From: Carley Lavender <Carley.Lavender@arun.gov.uk>
Sent: 29 July 2026 10:18
To: Planning <Planning@arun.gov.uk>; Amber Willard <Amber.Willard@arun.gov.uk>; Daniel Vick <Daniel.Vick@arun.gov.uk>
Cc: Committees <Committees@arun.gov.uk>; Cllr. Francis Oppler <cllr.francis.oppler@arun.gov.uk>
Subject: FW: 63 Annandale Ave (BR/82/26/PL)

From: YC [REDACTED]
Sent: 28 July 2026 22:14
To: Committees <Committees@arun.gov.uk>; Cllr. Francis Oppler <cllr.francis.oppler@arun.gov.uk>
Subject: 63 Annandale Ave (BR/82/26/PL)

I'd like to express my concerns about the parkings as mentioned and the trees/bushes outside the house.

| DRAWING<br>Proposed<br>Block Plan         |                  |

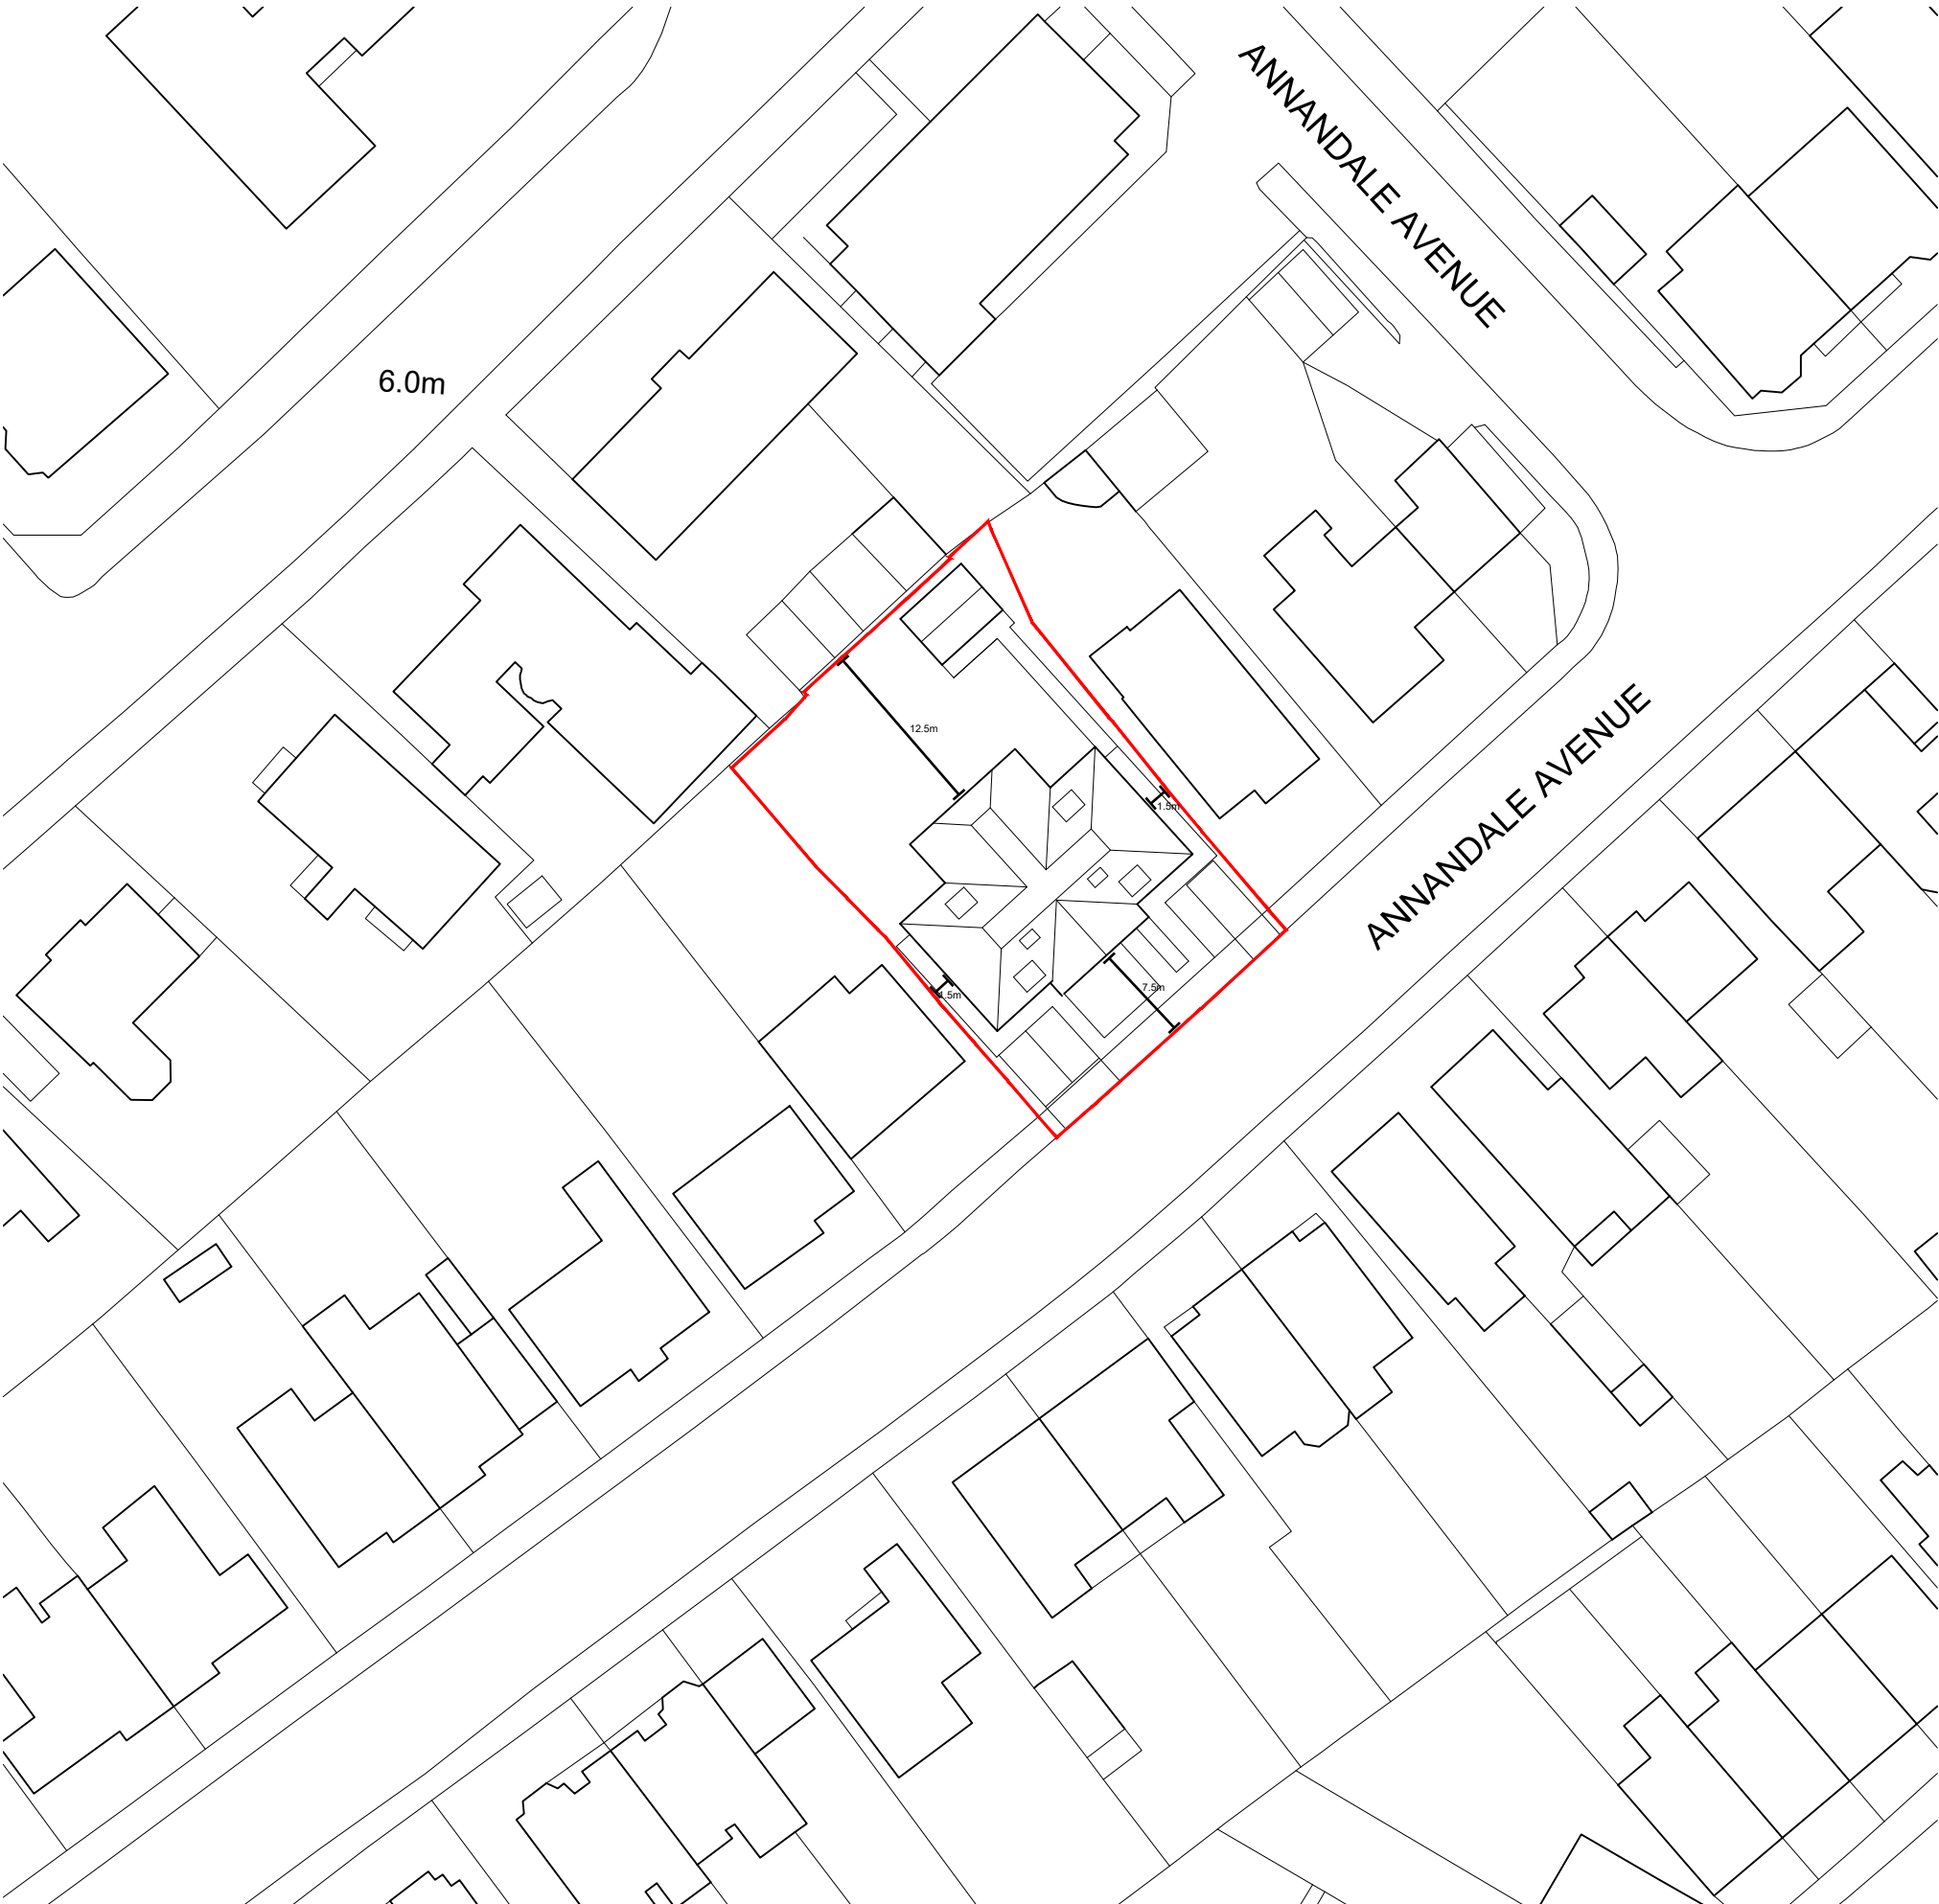
As the road lacks of the parking space, the new development should build their own parkings in their land and they should get rid of the tress/bushes or let it be in their land, not using the pedestrian space!

The bushes cover the pedestrian walkway, there's no space to walk by!

And if they build a building in line with the road, that would be good ~
